Subject: RE: Planning Consultation on: BE/27/20/PL

APPLICATION NO: BE/27/20/PL

Site Address: Land at Salt Box West of Shripney Road Bersted

Description of Works: Creation of temporary soil storage bund & haulage route associated with development of adjoining site at Saltbox (resubmission following BE/38/19/PL). This application may affect the character & appearance of the Shripney Conservation Area & is a Departure from the Development Plan.

TOP SOIL RELOCATION  
 SITE PLAN  
 1744-TS-P02-E

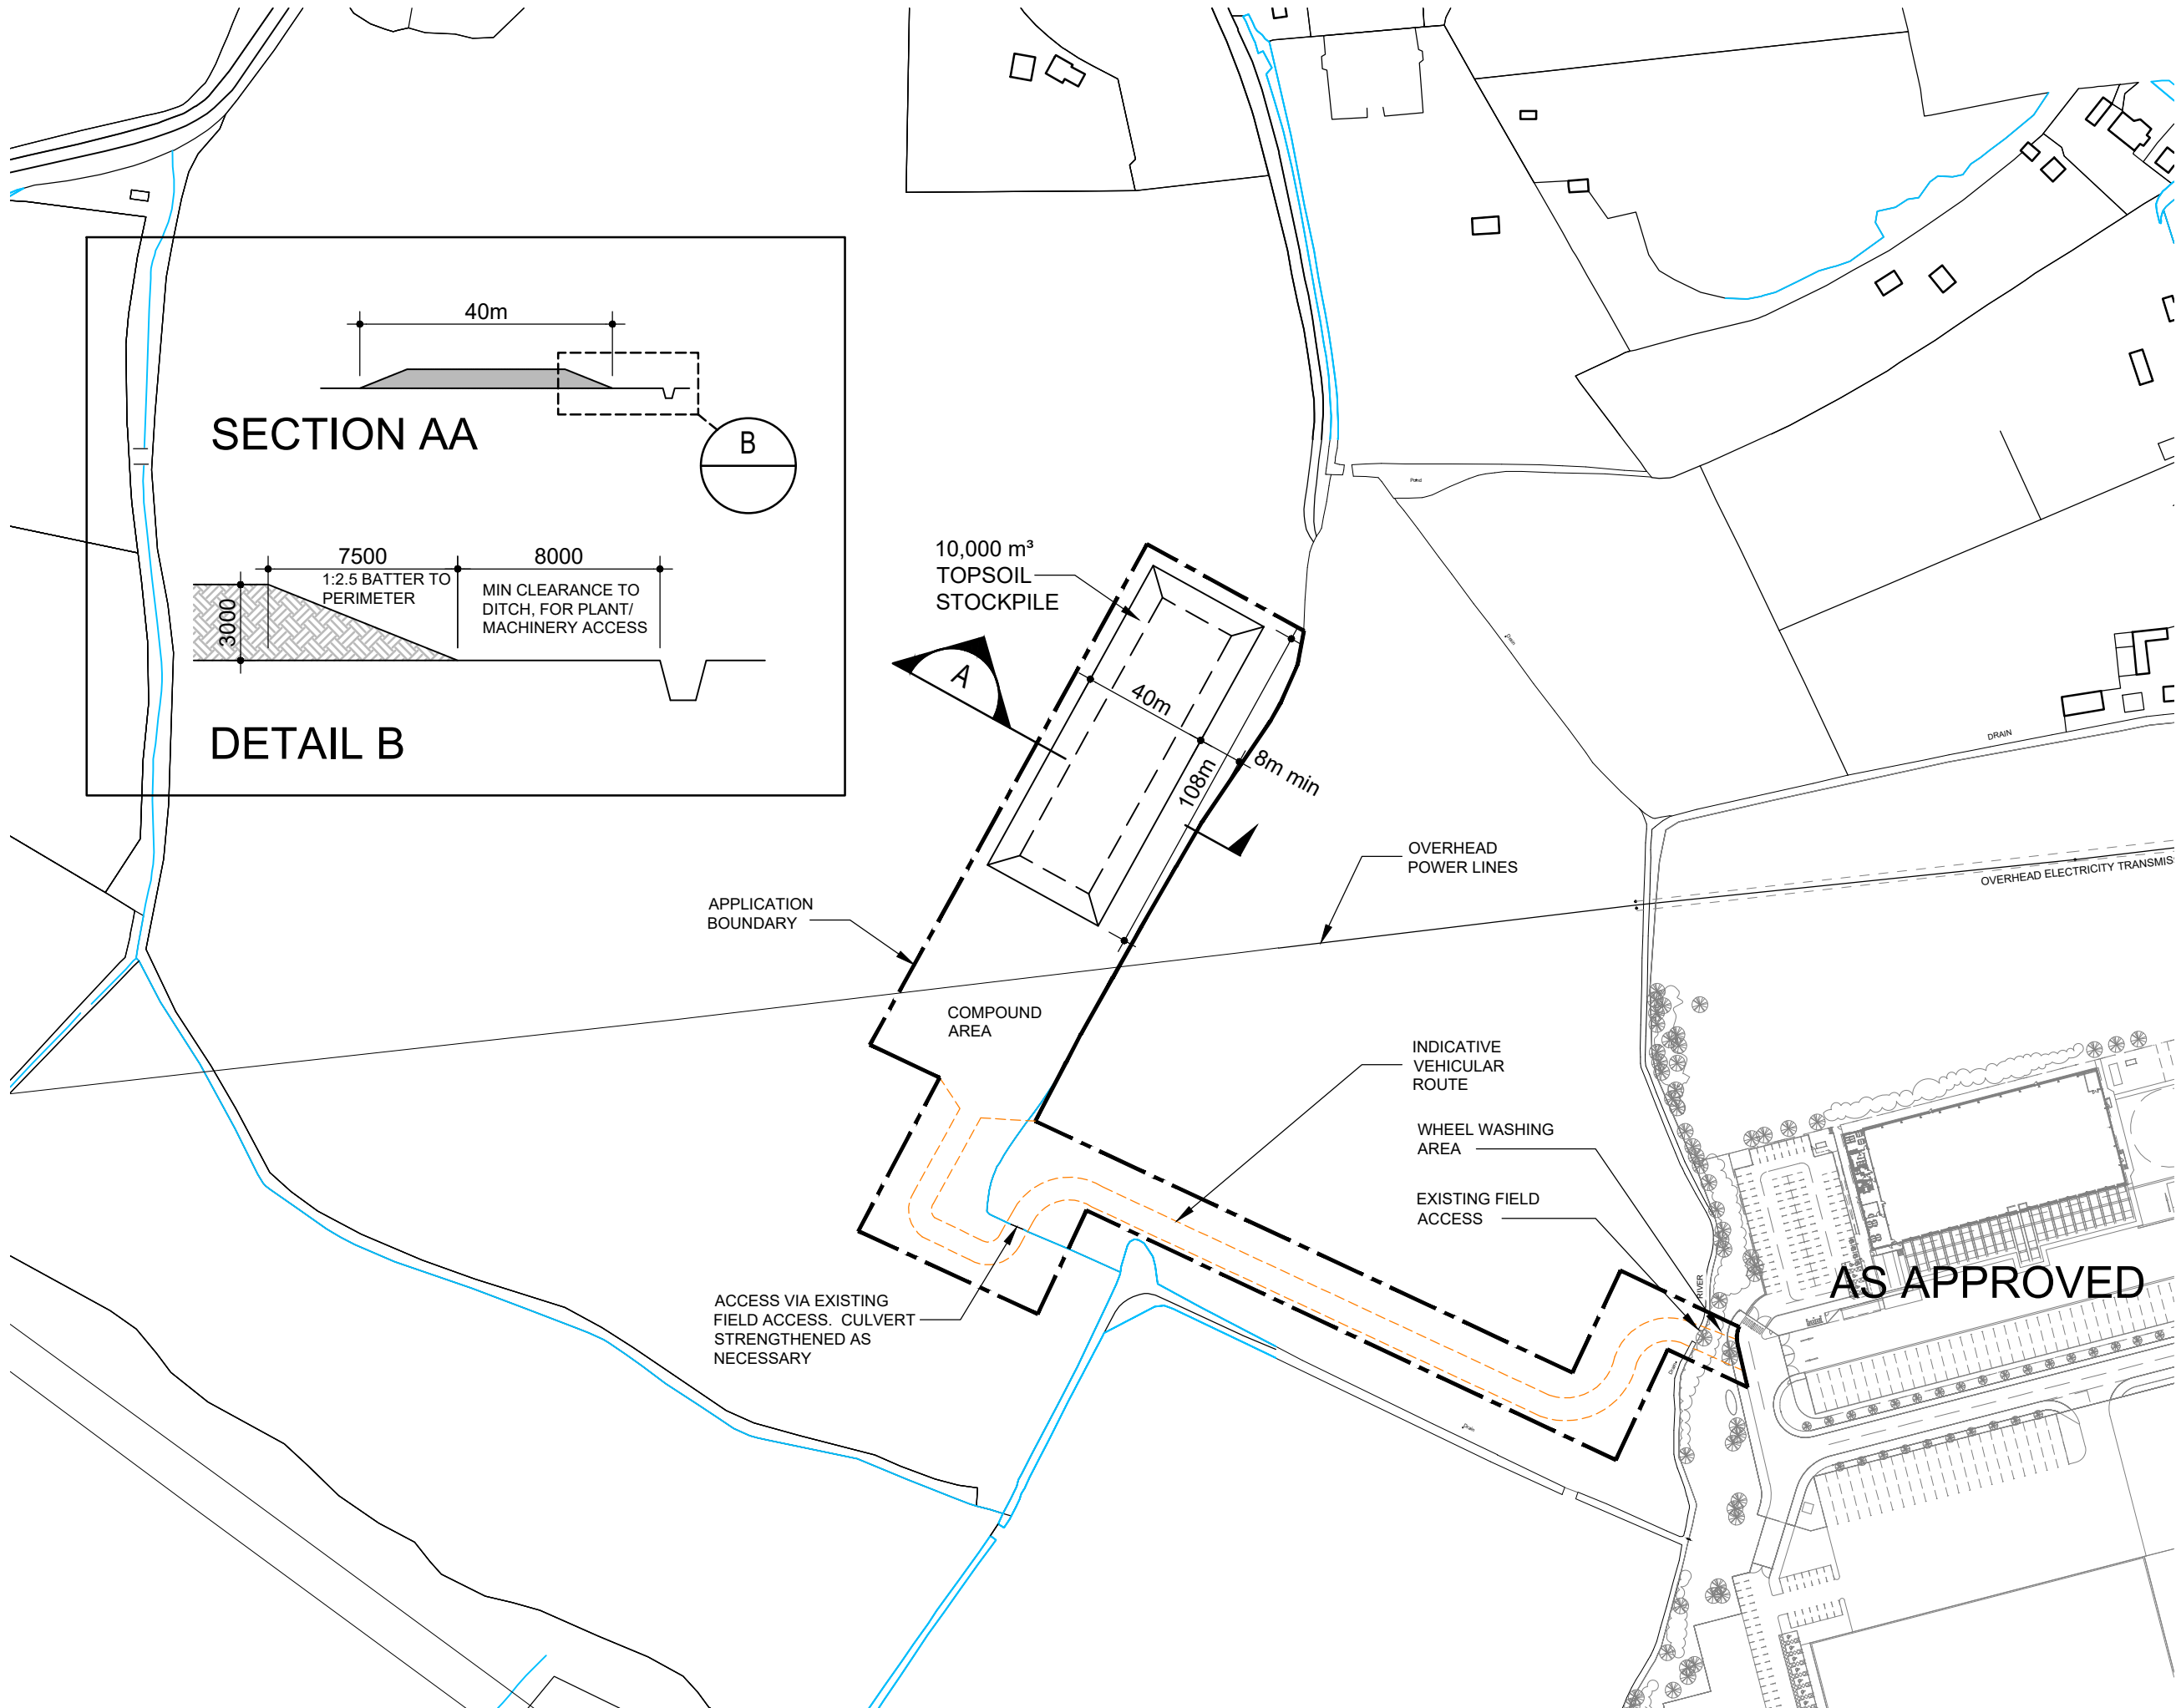
I now have been informed that the stockpile will not be covered and therefore drainage provision will not be required around its perimeter.

The proposal involves the proposed haulage road crossing existing culverts on the 'main river' section of watercourse and the 'ordinary' watercourse. It is noted that strengthening may be required on the ordinary watercourse culvert, in which case, the proposals will need to be agreed with ourselves. Any works to the main river culvert will need to be agreed with the Environment Agency (EA).

I note that the stock pile will be kept sufficiently clear of the watercourses.

The stock piled material is proposed to comprise of top soil only, and if that is the case, the applicant will not need to make allowance for introducing drainage around the perimeter. However, if the stock pile is to be covered with an impermeable membrane in order to prevent erosion/weed growth or consists of material less permeable than topsoil, then drainage measures will be required to ensure that the surface water run off does not increase flood risk elsewhere. Therefore, depending on the finer details of the proposal, it may be necessary to condition the application accordingly.
